15 November 2018

Kings Forest Project Application MP08 /0194 MOD 4 – Response to Submissions - Revised KOALA PLAN OF MANAGEMENT

INDICATIVE LOCATION OF PERMANENT FENCING IN CUDGEN Paddock

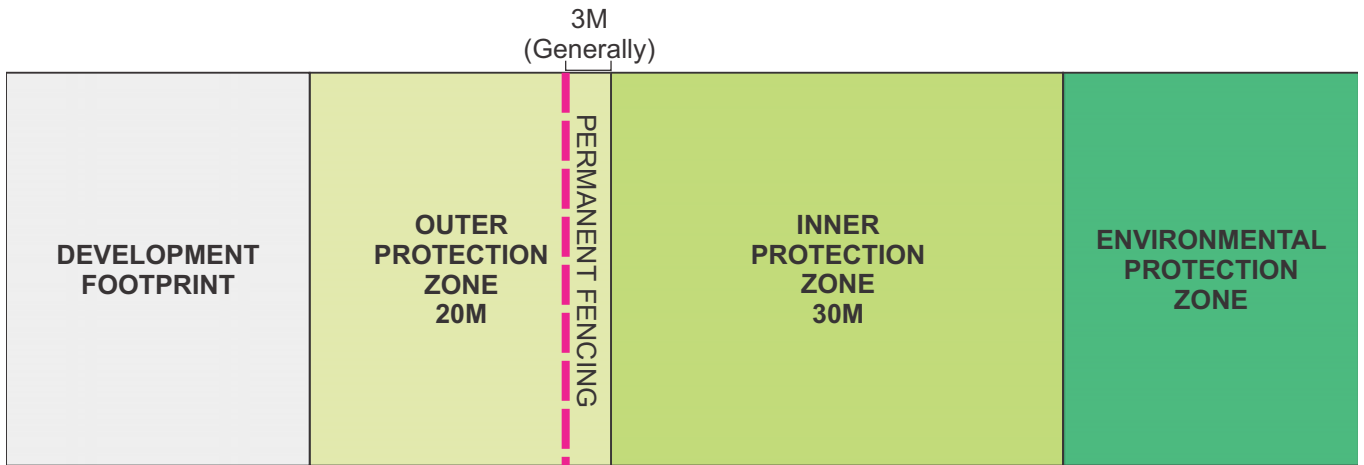
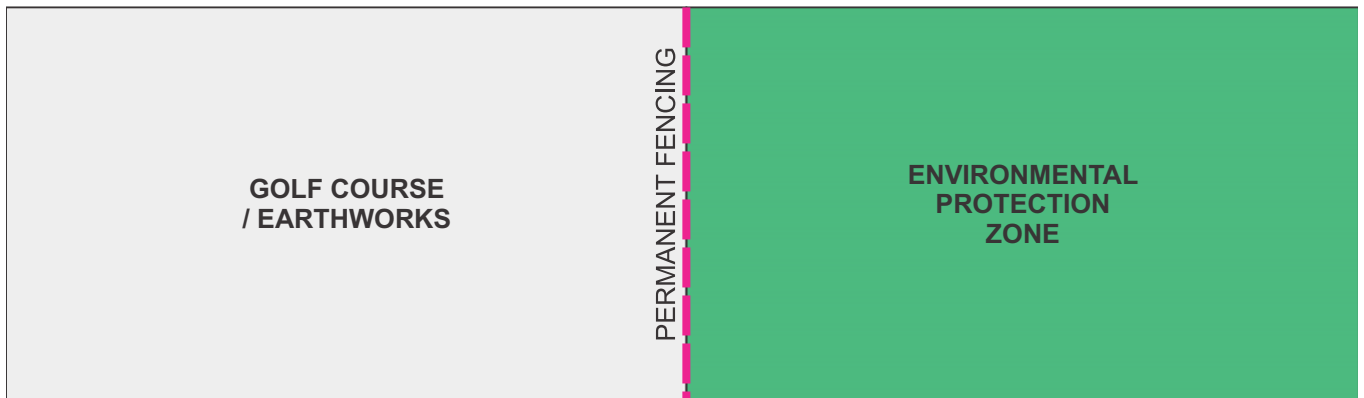
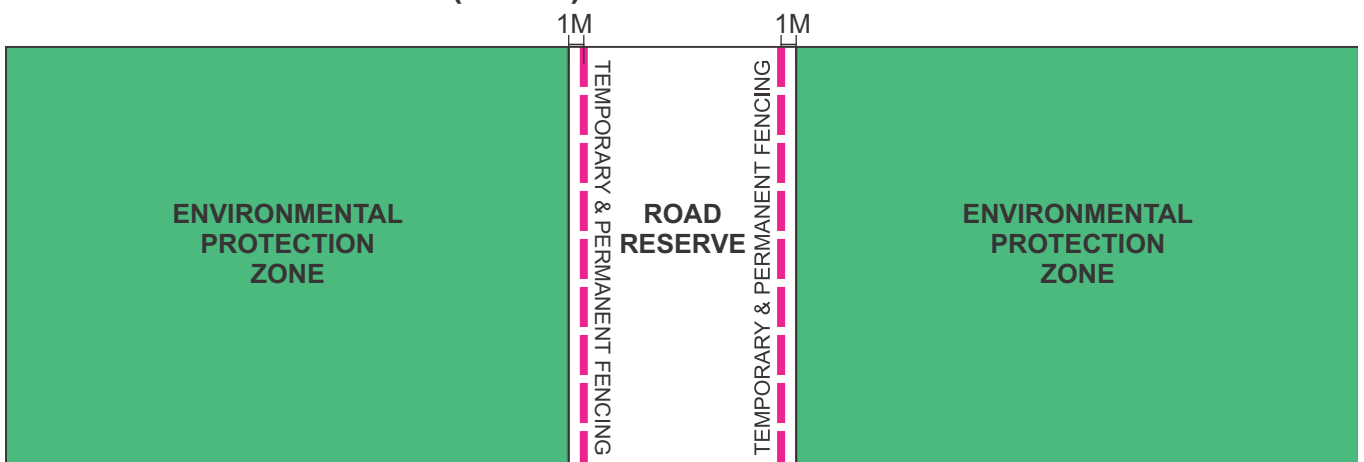
- The proposal to install permanent fauna exclusion fencing on the inside of the Ecological Buffer in the “Cudgen paddock” (see middle diagram on Fig 28; see also Fig 40B) is inconsistent with the ecological buffer requirements of the Kings Forest Major Projects SEPP and the Concept Plan which contemplated koalas using the proposed Golf Course which would act as a buffer. The fauna exclusion fencing should encompass the golf course itself.

3. Further clarification was needed on how the permanent fencing proposed for the “Cudgen paddock” (see middle diagram on Fig 28) will adequately address the requirement for a 50m ecological buffer in this location. It was understood that the original Concept Plan contemplated koalas using the proposed Golf Course which would act as a buffer. If this was no longer to occur, a hard barrier to terrestrial fauna at the inside of the Ecological Buffer may not function as intended. It was recommended that consideration be given to locating the permanent fencing on the inner protection zone (30m) with the Golf Course extending into the 20m outer protection zone of the Ecological Buffer. This was the case elsewhere on the development site (see top diagram on Fig 28). Alternatively, fauna exclusion fencing could encompass the golf course itself.

3. The proposal to install permanent fencing on the inside of the Ecological Buffer in the “Cudgen paddock” (see middle diagram on Fig 28; see also Fig 40B) is inconsistent the ecological buffer requirements of the Kings Forest Major Projects SEPP and is not supported. It is understood that the original Concept Plan contemplated koalas using the proposed Golf Course which would act as a buffer. To be consistent with the Concept Plan the fauna exclusion fencing should encompass the golf course itself. If this is no longer the intention, it is recommended that consideration be given to locating the permanent fencing on the inner protection zone (30m) with the Golf Course extending into the 20m outer protection zone of the Ecological Buffer. This is the case elsewhere on the development site (see top diagram on Fig 28).

TITLE
INDICATIVE FAUNA UNDERPASS DESIGN

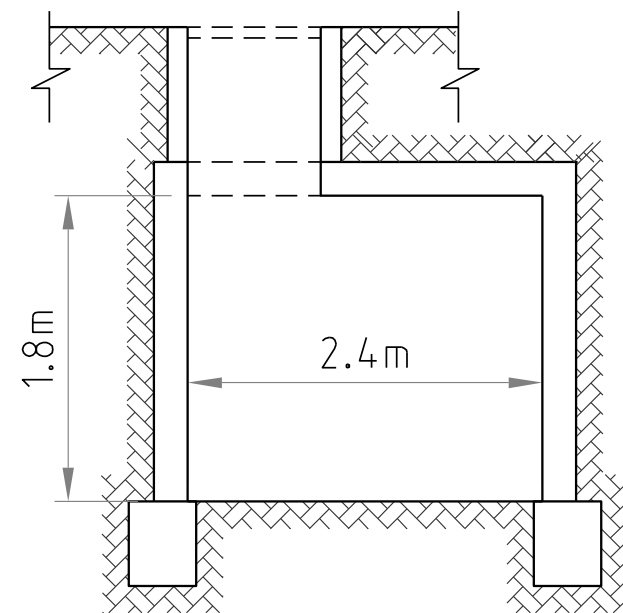
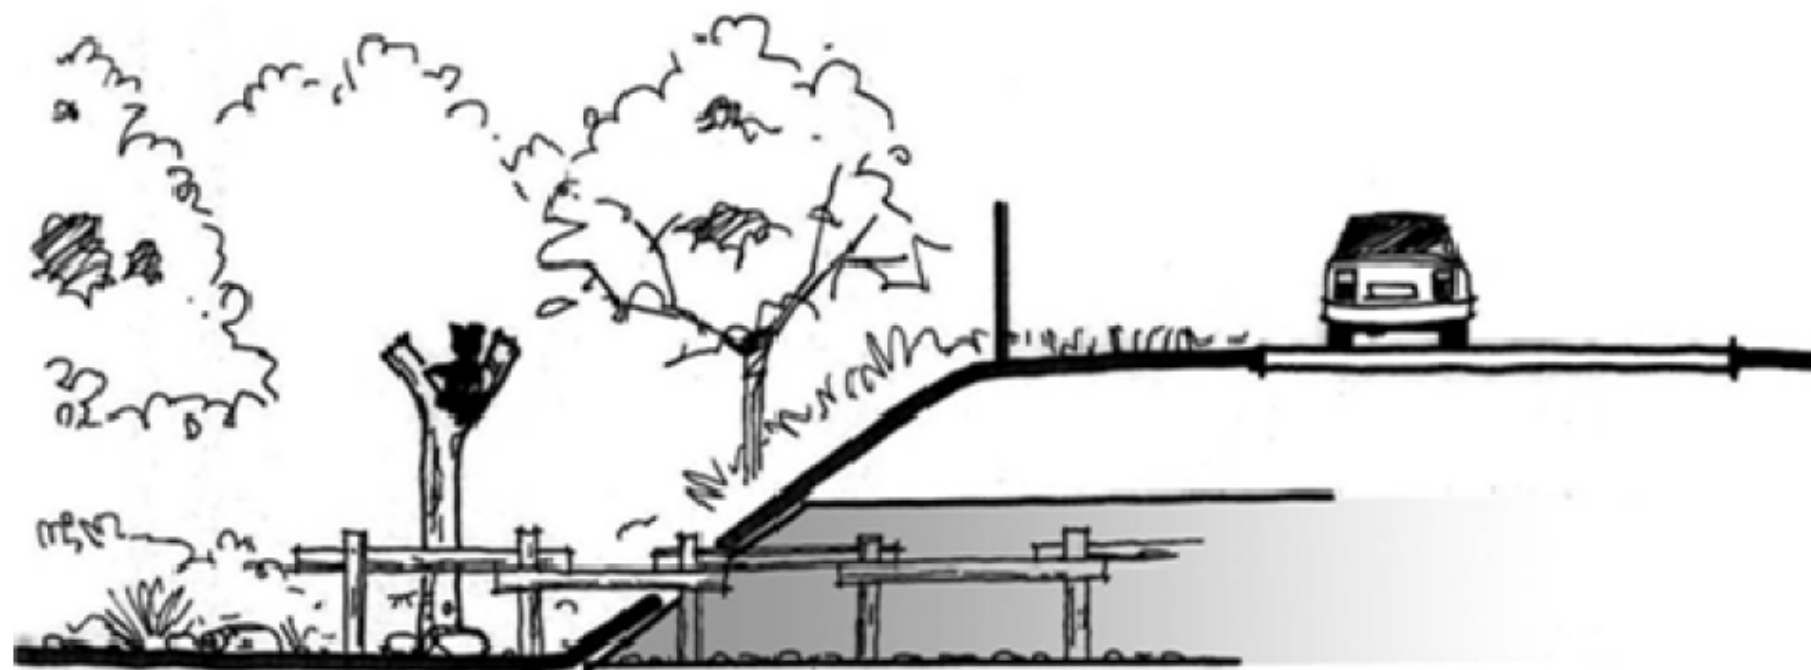
- The draft revised KPOM continues to state that underpass number 5 over Blacks Creek “is unlikely to provide underpass opportunities for koalas” (p82; October 2018). It is recommended that the bridge abutments be set back 2m on either side of the banks as shown for the Culvert 9 cross-section (Fig 30C).

1. The indicative locations of a number of fauna underpasses were shown on Fig 30A of the draft revised KPOM (May 2018) and indicative cross-sections for these structures were illustrated on Figs 30C and 30D. However, it was not clear which sections apply to which of the numbered underpasses on Fig 30A. Without this information it was not possible to adequately comment on their likely suitability.

2. The draft revised KPOM (p68; May 2018) mentioned that underpass number 5 over Blacks Creek was “unlikely to provide underpass opportunities for koalas”. To address this issue it was recommended that the bridge abutments be set back 2m on either side of the banks as shown on the cross-section illustrated at the bottom of Fig 30C.

1. Recent amendments to Figs 30C and 30D now make it clear which sections apply to which of the numbered underpasses on Fig 30A. The design of these structures appear appropriate subject to the following points.
2. The draft revised KPOM (p82; October 2018) continues to state that the underpass number 5 over Blacks Creek “is unlikely to provide underpass

opportunities for koalas”. The previous recommendation of July 2018 is reiterated; that the bridge abutments be set back 2m on either side of the banks as shown for the Culvert 9 cross-section (Fig 30C). This will allow two underpasses - one dual purpose (drainage and low flow fauna access) and one permanent dry passage - for both north-south roads that traverse the East-West Corridor.
